From: Jean Fraser
To: David Latulippe
Date: 11/10/2015 3:20 PM
Subject: Ramps/steps in ROW Re: 20 Marginal Way - Bangor Savings

Drawing No.
C102

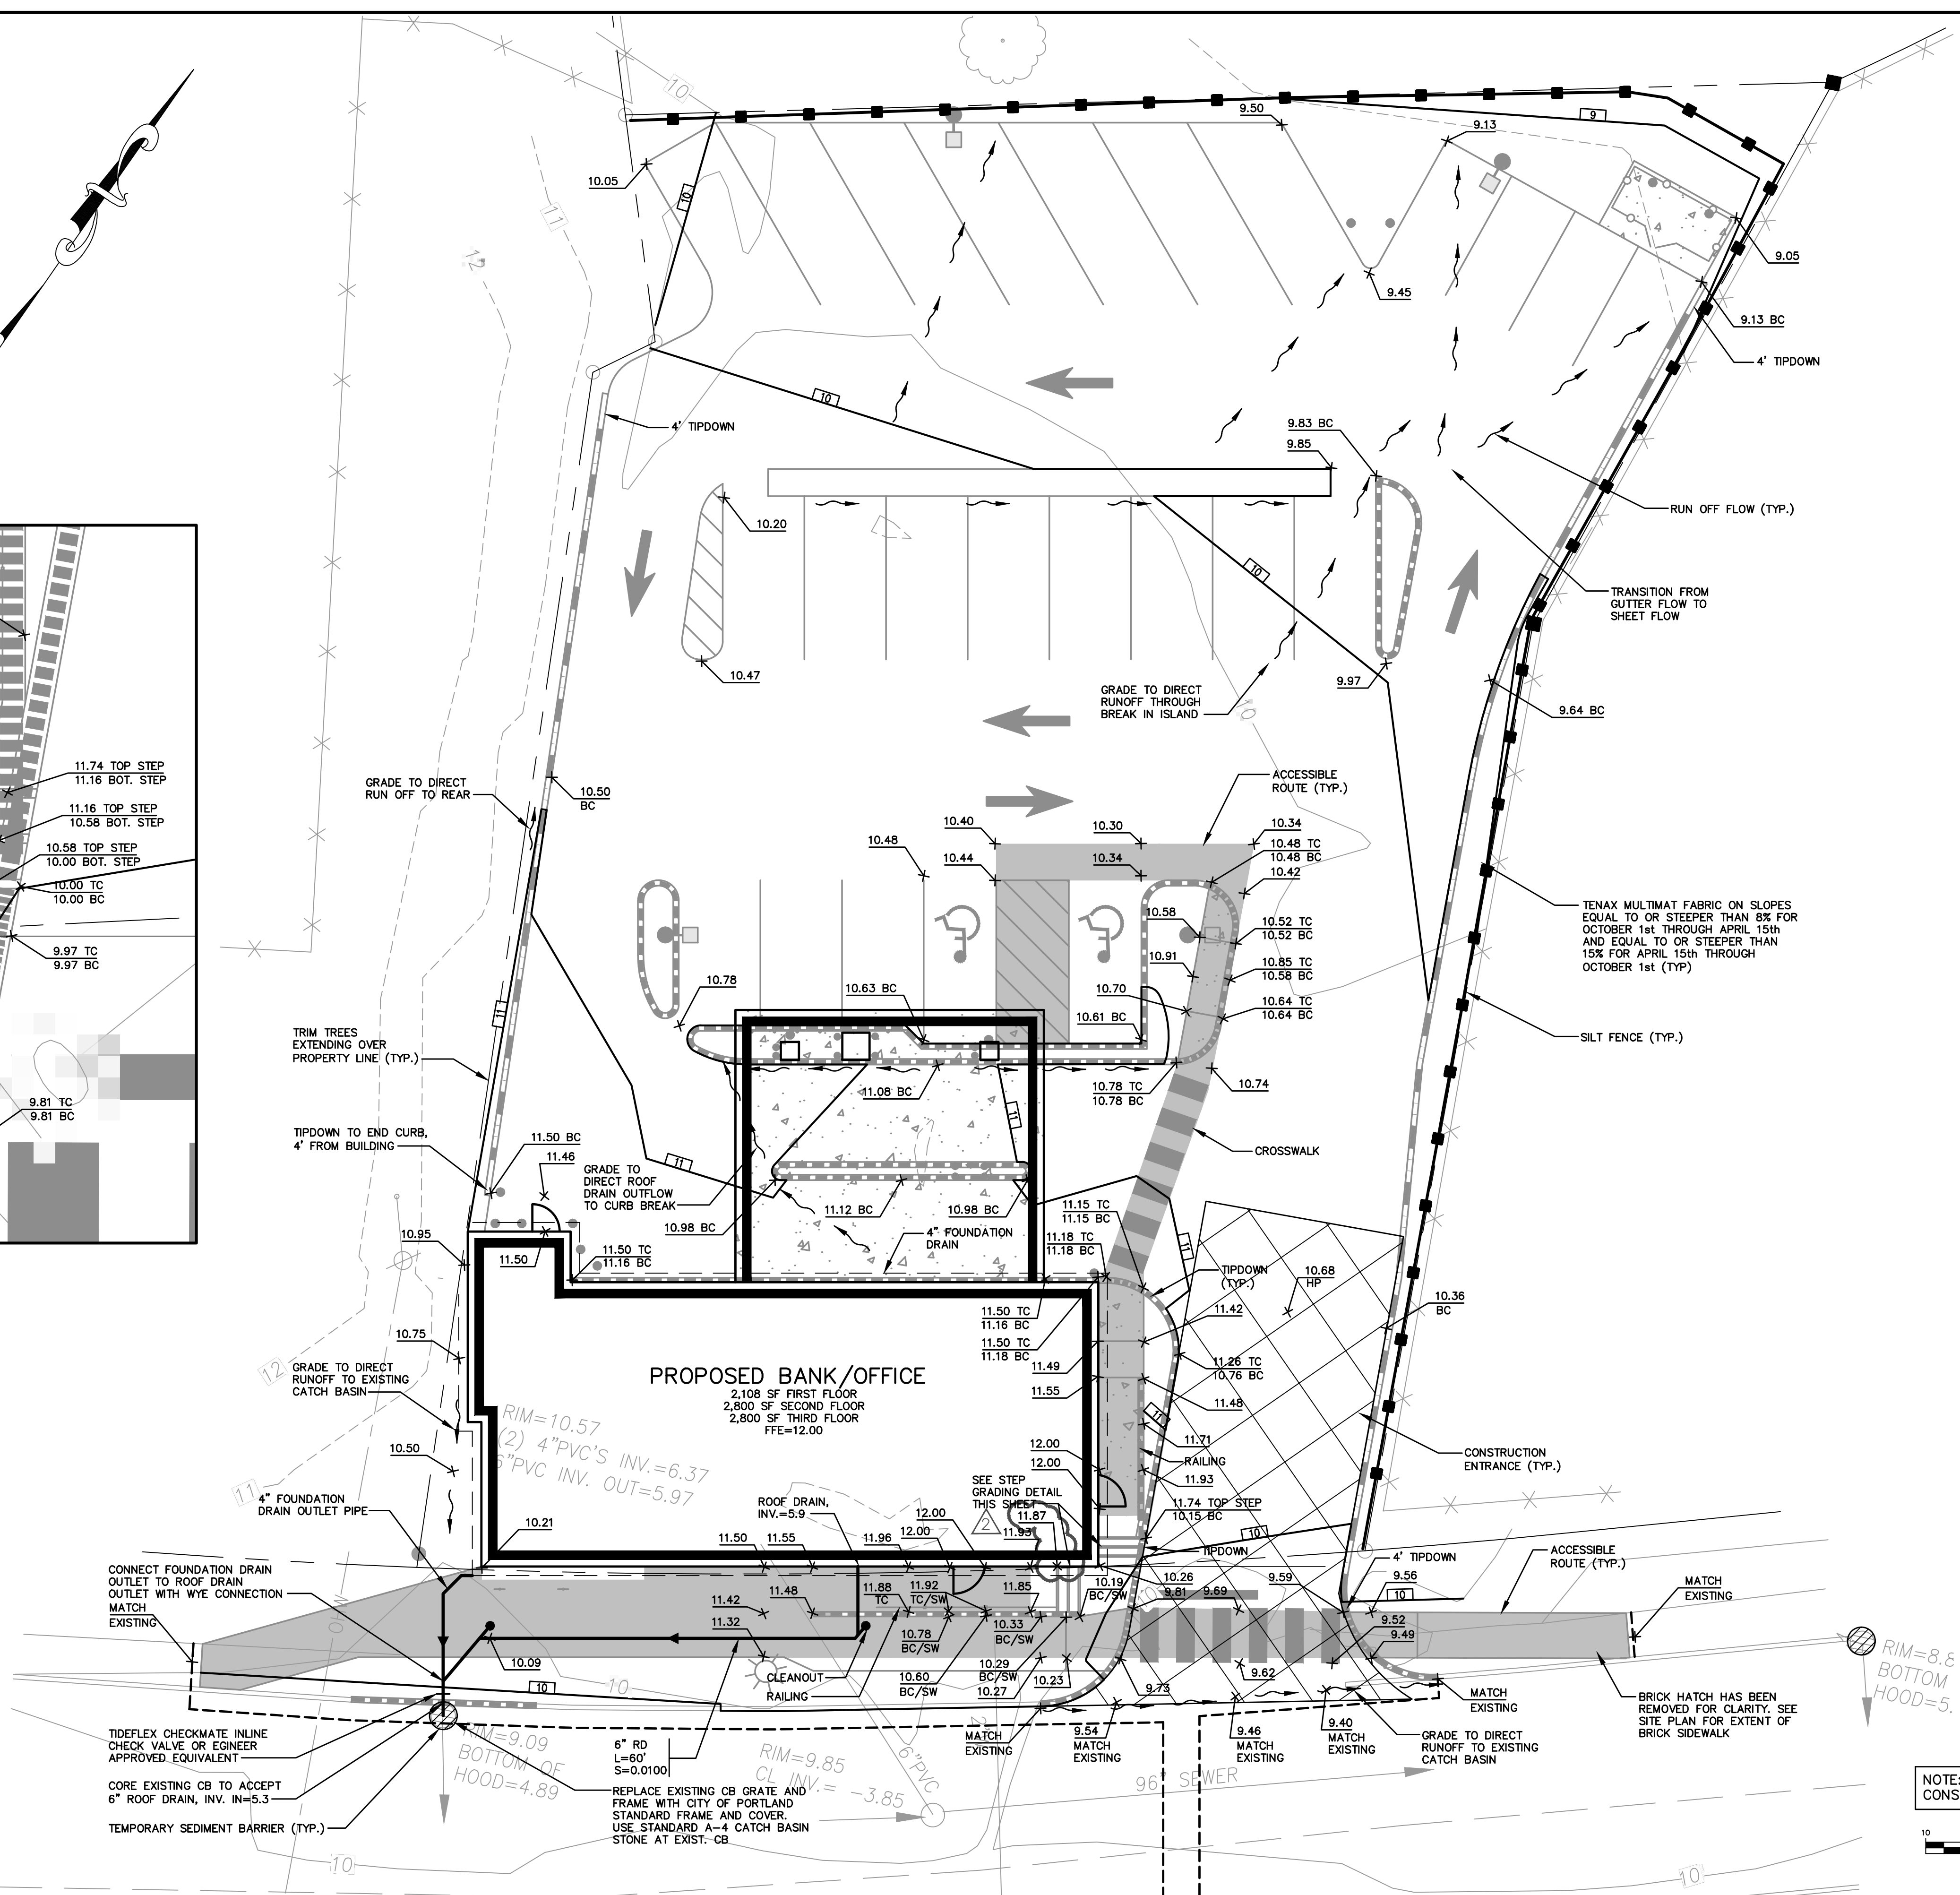
In addition to the previous questions re details of the materials and confirmation re compliance with ADA, staff have recently raised a few other concerns that they would like further info/discussion on:
what are the resulting cross-slope and running slopes - need annotations on drawing
how the ADA access from the parking lot will be provided with the bike racks located as on the plan (I think the City might be OK with the racks in the ROW subject to discussion, as the placement near the building as waived is not a great solution)
the ramps/steps will require a license from the City that will specify maintenance arrangements at least for the steps and ramps/railings - so that may need further discussion.
I realize a meeting may entail extra expense in terms of time for attending the meeting, but may save costs of drawing a number of plans for e-mailed comments- and may get a better result for all as there would be the opportunity to understand the objectives/concerns of all parties.
